**Our ref:** RA/2025/148546/01-L01  
**Your ref:** 2025/90922  
**Date:** 29 July 2025

**ERECTION OF OUTBUILDING, EXTENSION OF EXISTING GARAGE AND ASSOCIATED ALTERATIONS NEWGATE GARAGE, NEWGATE, MIRFIELD, WF14 8DB**

**Environment Agency Position**

PROPOSED BLOCK PLAN
1:500

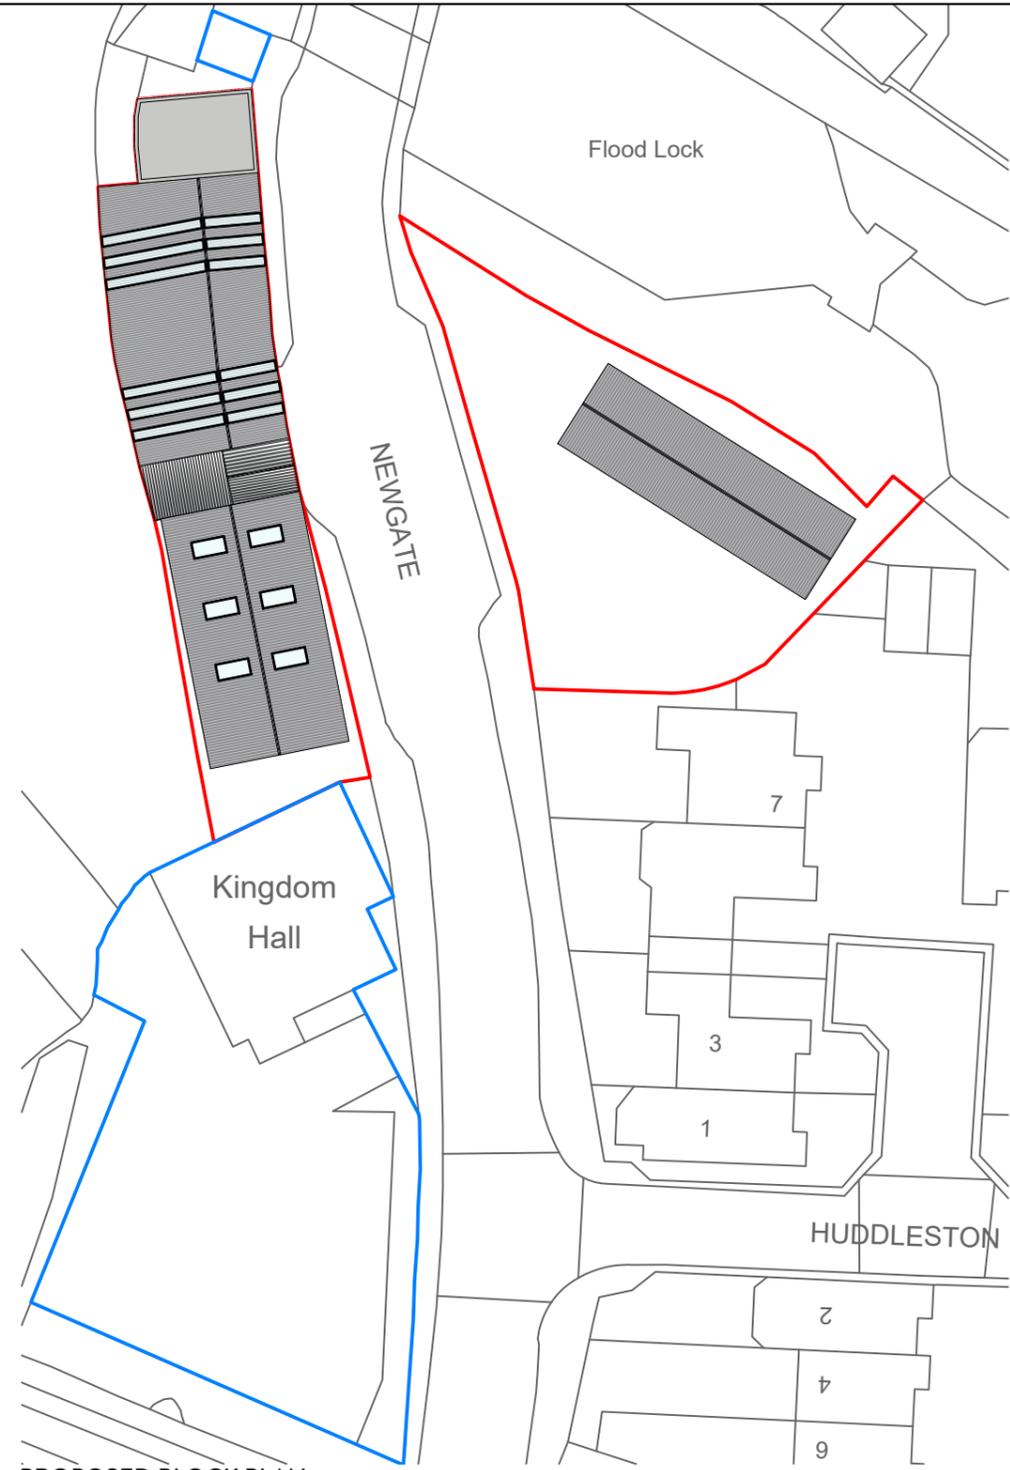
We object to this application as it involves building works within 2 metres of watercourse. As submitted, it is unlikely that we would grant a flood risk activity permit for this application.

- The proposed development would restrict essential maintenance and emergency access to the watercourse. The permanent retention of a continuous unobstructed area is an essential requirement for future maintenance and improvement works.
- The proposed development may obstruct flood flows; it thereby may increase the risk of flooding to the communities of Mirfield and Lower Hopton.
- The building/structure may interfere with natural geomorphological processes and could be placed at risk of damage arising from channel migration/erosion.

We usually request that the proposals are revised so that an 8-metre buffer zone is maintained between the development and the top of the riverbank

1. No detrimental impact to the stability of the riverbank.
2. A suitable unobstructed area for maintenance and improvement works.
